State of Washington
DEPARTMENT OF FISH AND WILDLIFE
South Central Region • Region 3 • 1701 South 24th Avenue, Yakima, WA 98902-5720
Telephone: (509) 575-2740 • Fax: (509) 575-2474

December 2, 2019

SUBJECT: WDFW COMMENTS ON SV-19-00001 THAYER SHORELINE VARIANCE

SEPTEMBER 2019
THAYER PROPERTY DEVELOPMENT
FOR SINGLE FAMILY RESIDENCE
ACCESS BRIDGE SITE PLAN
DRAWING 4

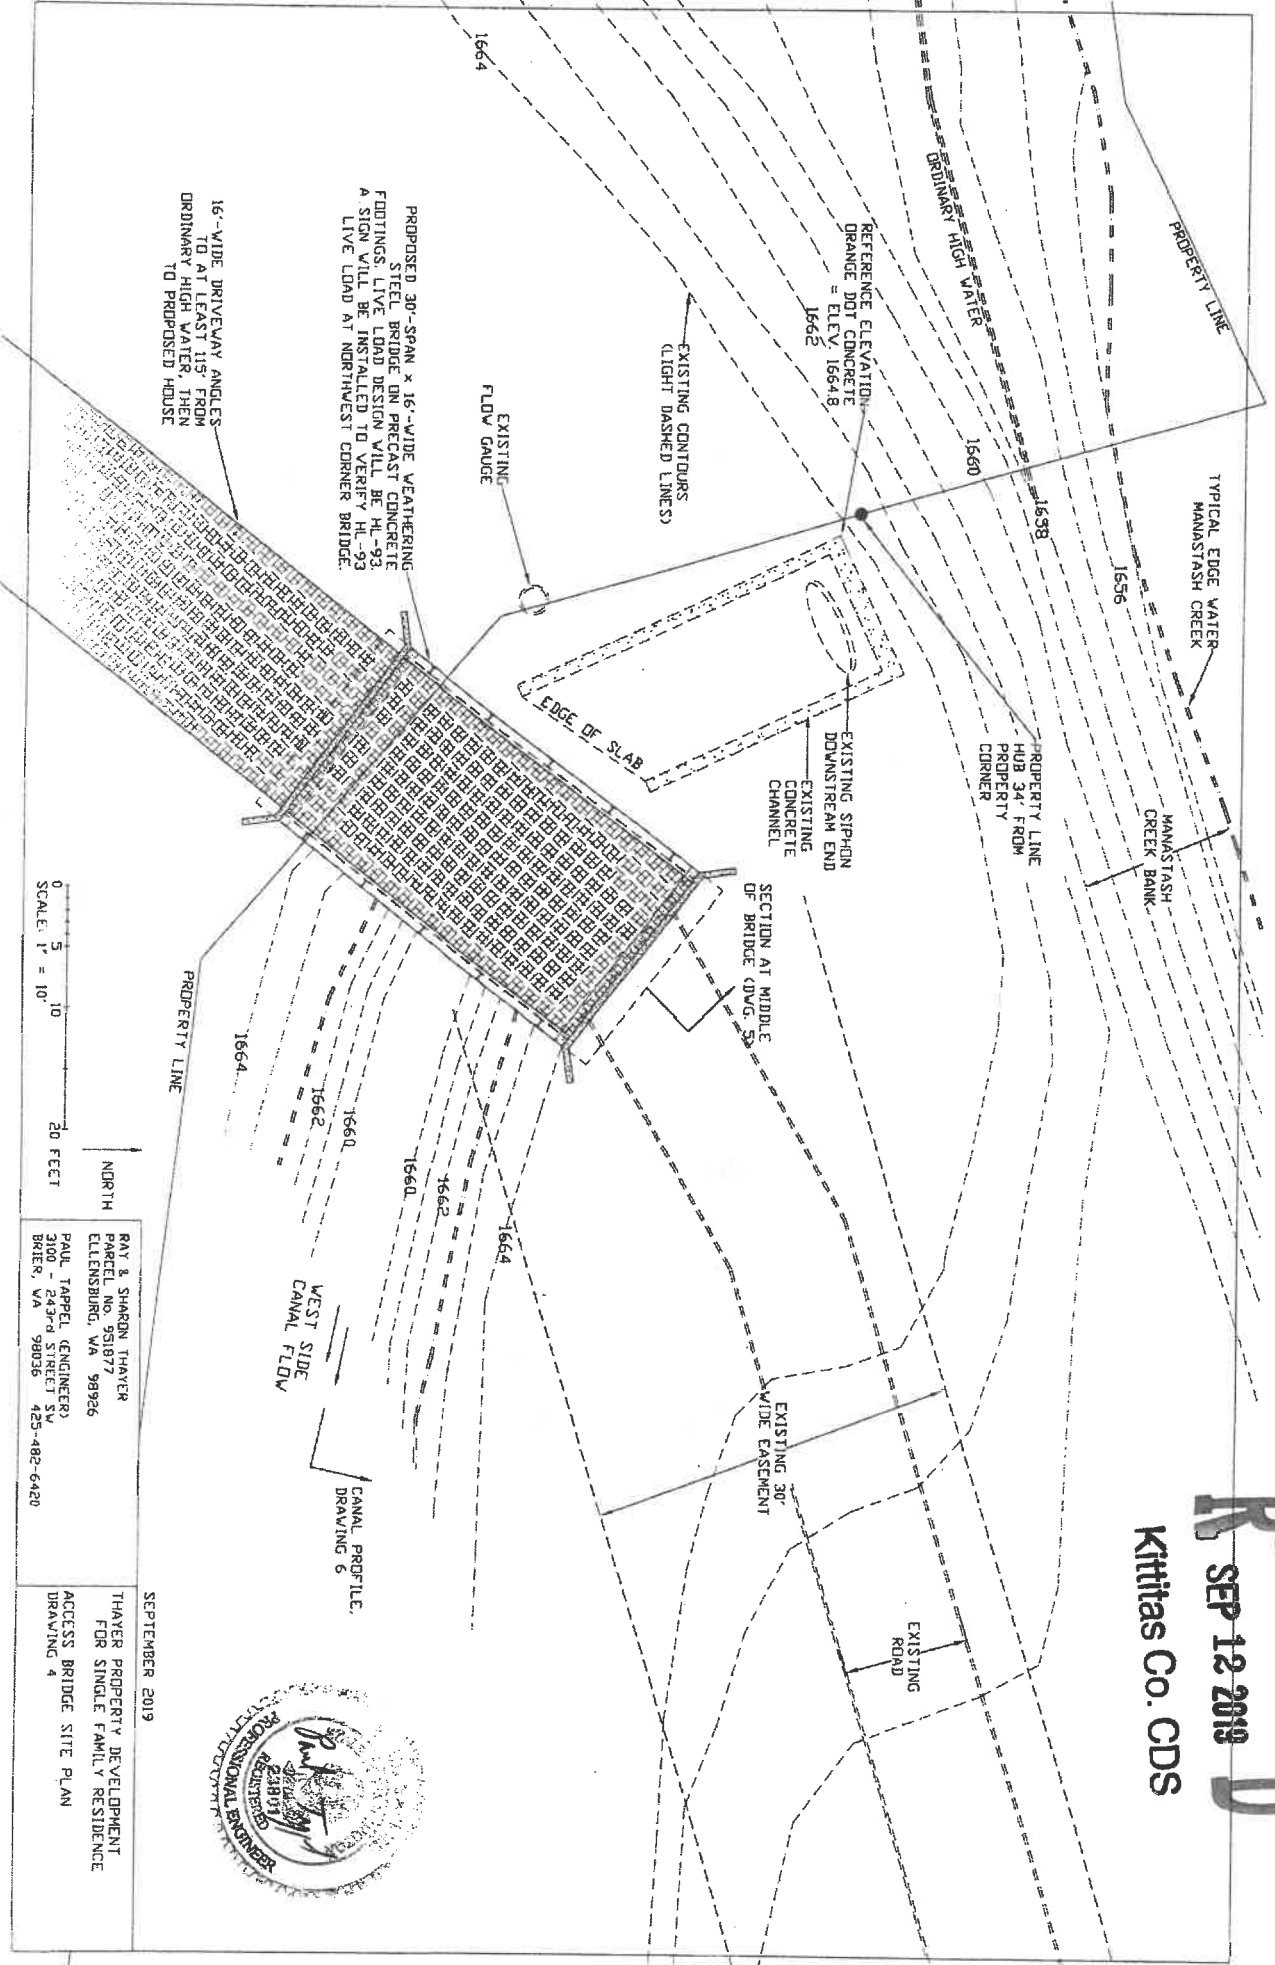
- If the driveway location cannot be moved further from Manastash Creek due to existing legal easements, any widening of the existing driveway should occur landward from Manastash Creek and the elevation of the driveway not be elevated such that it could restrict or redirect flood flows. If it is possible our preference is to relocate the driveway and bridge further from the stream.
